# APPENDIX A – SUBMISSIONS REGISTER

## Public Authority and Agency Submissions

ELC - PROPOSED GA PLAN -
LEVEL -03

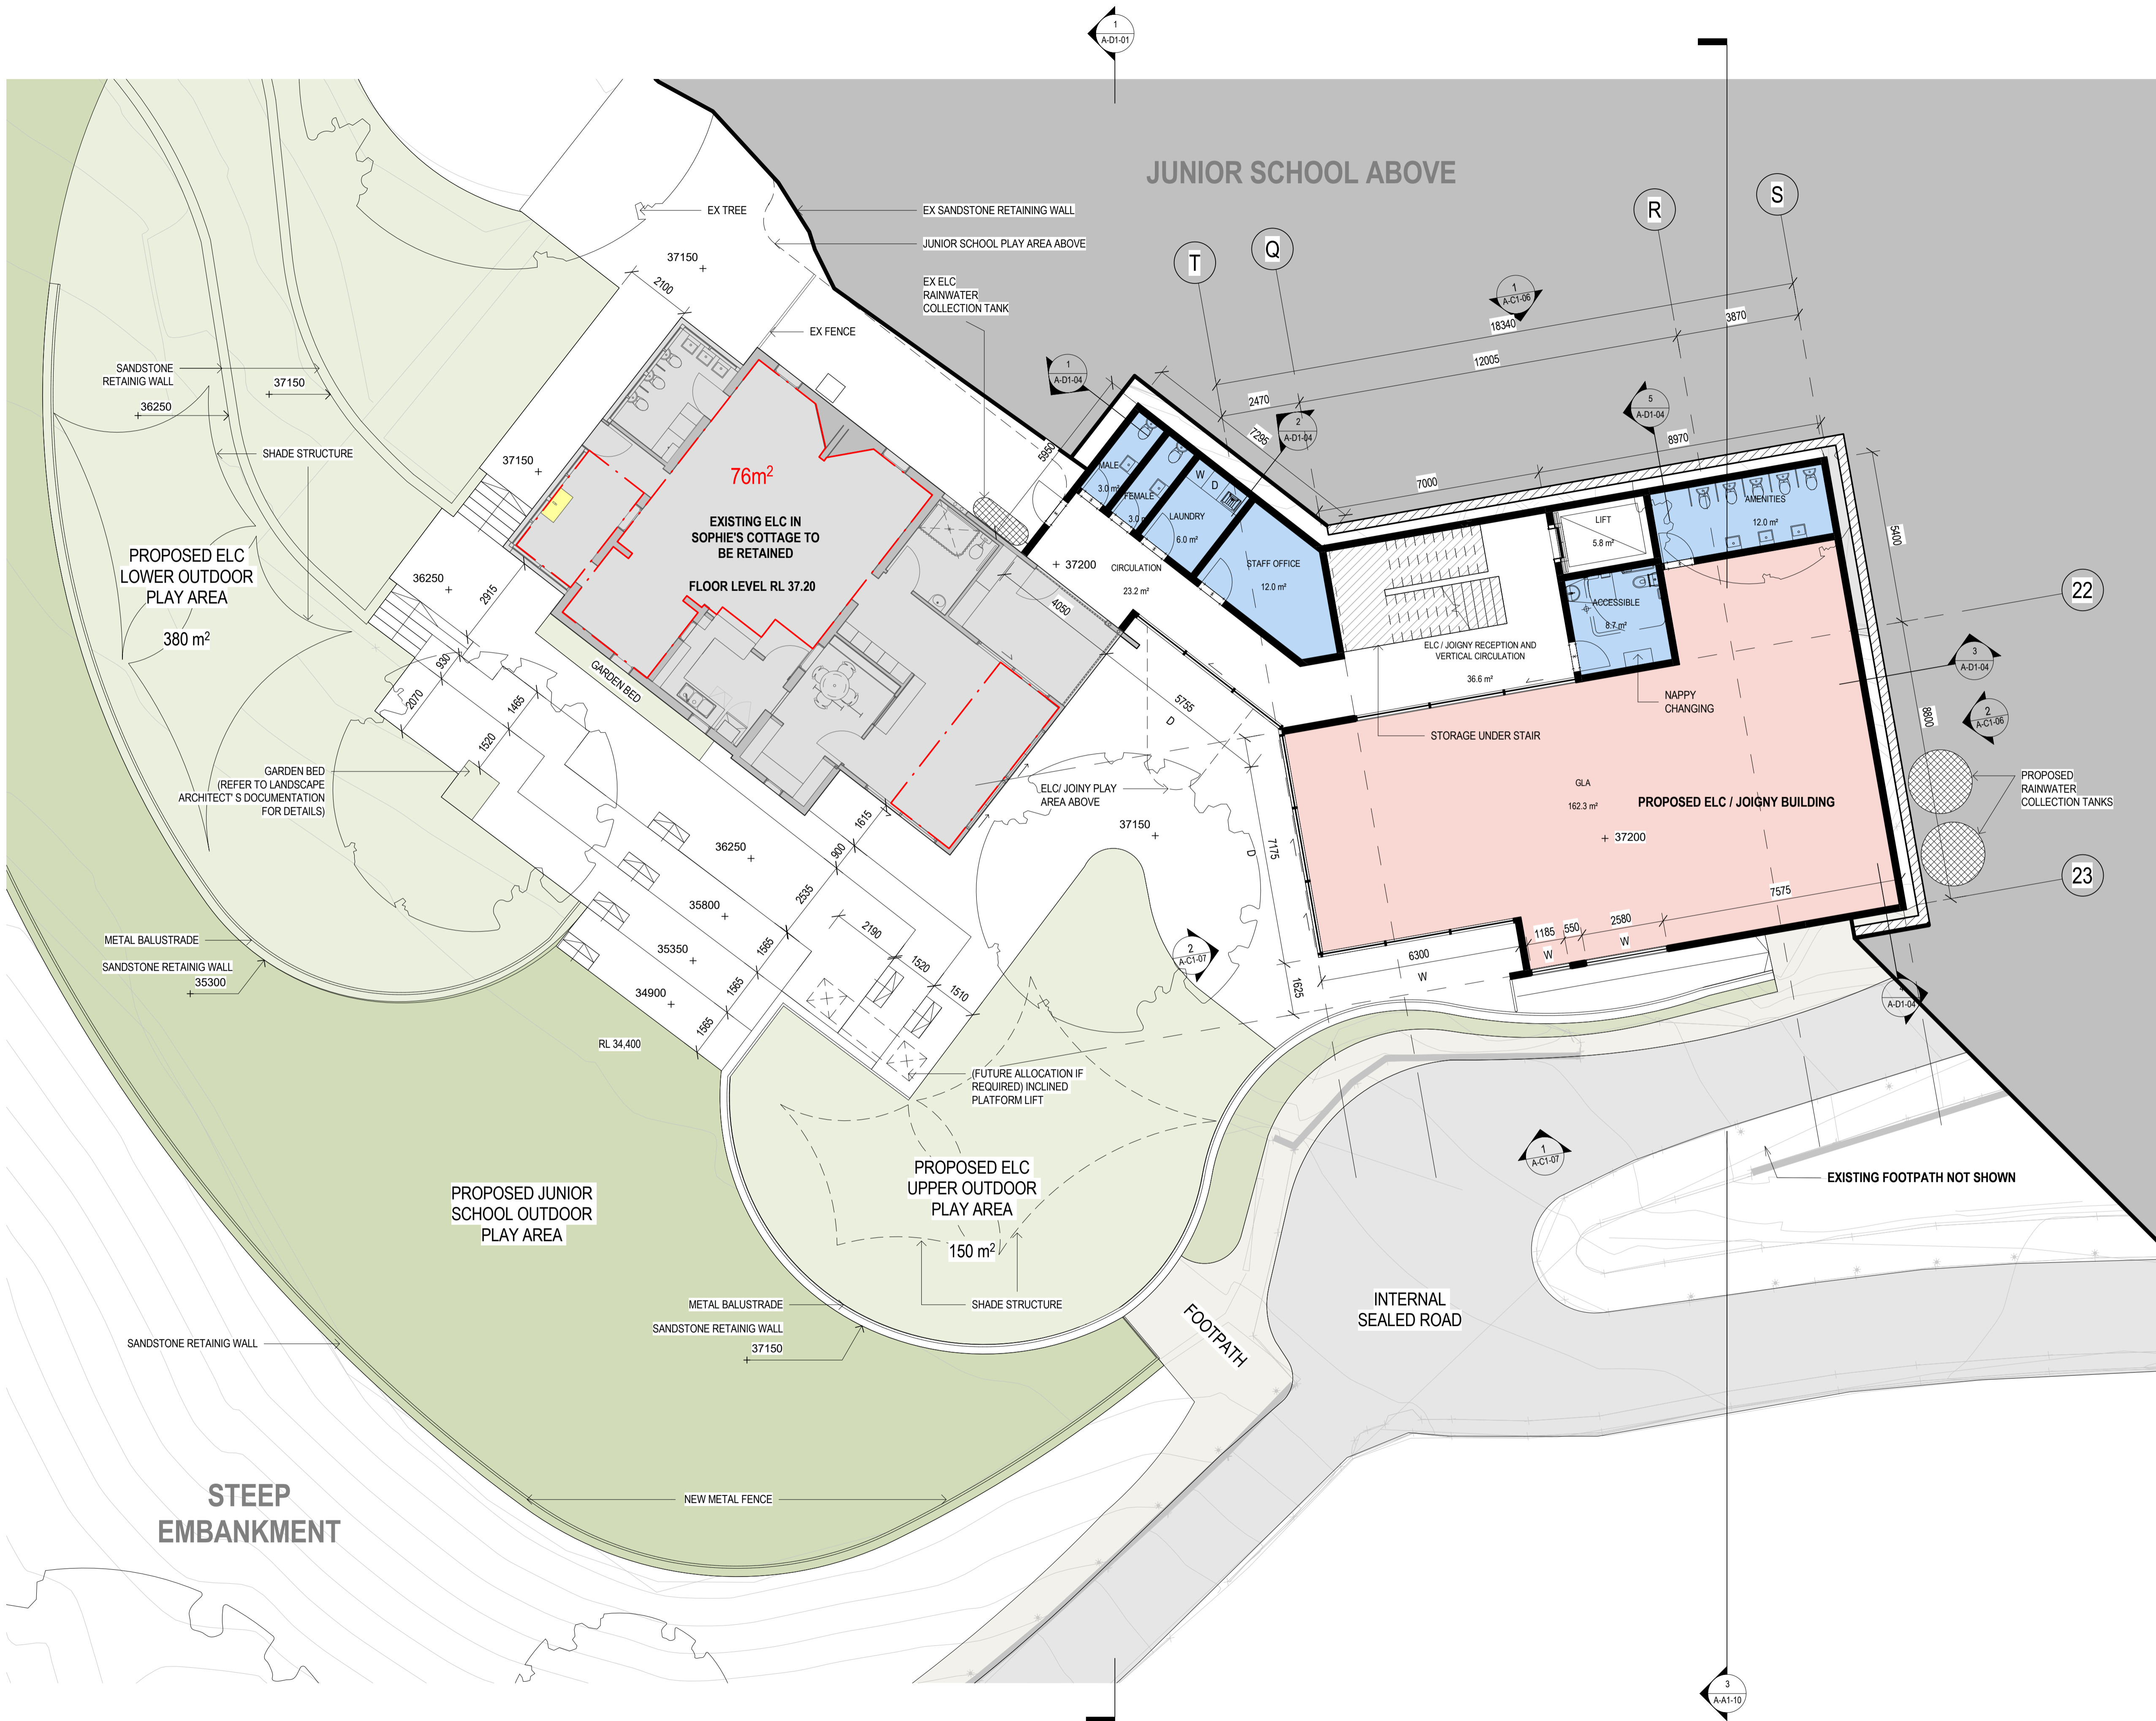
Laundry and nappy change facilities are required to be included within the proposed ELC building.	In accordance with the <i>Child Care Planning Guidelines 2017</i> , Drawing No. AR-A-B1-01 (ELC – Proposed GA Plan – Level -03) has been updated to identify the location of the proposed laundry facilities and nappy changing facilities. Refer to the Detailed Architectural Plans (ELC) included at <b>Appendix E1</b> for further details.	<b>Appendix E1</b>
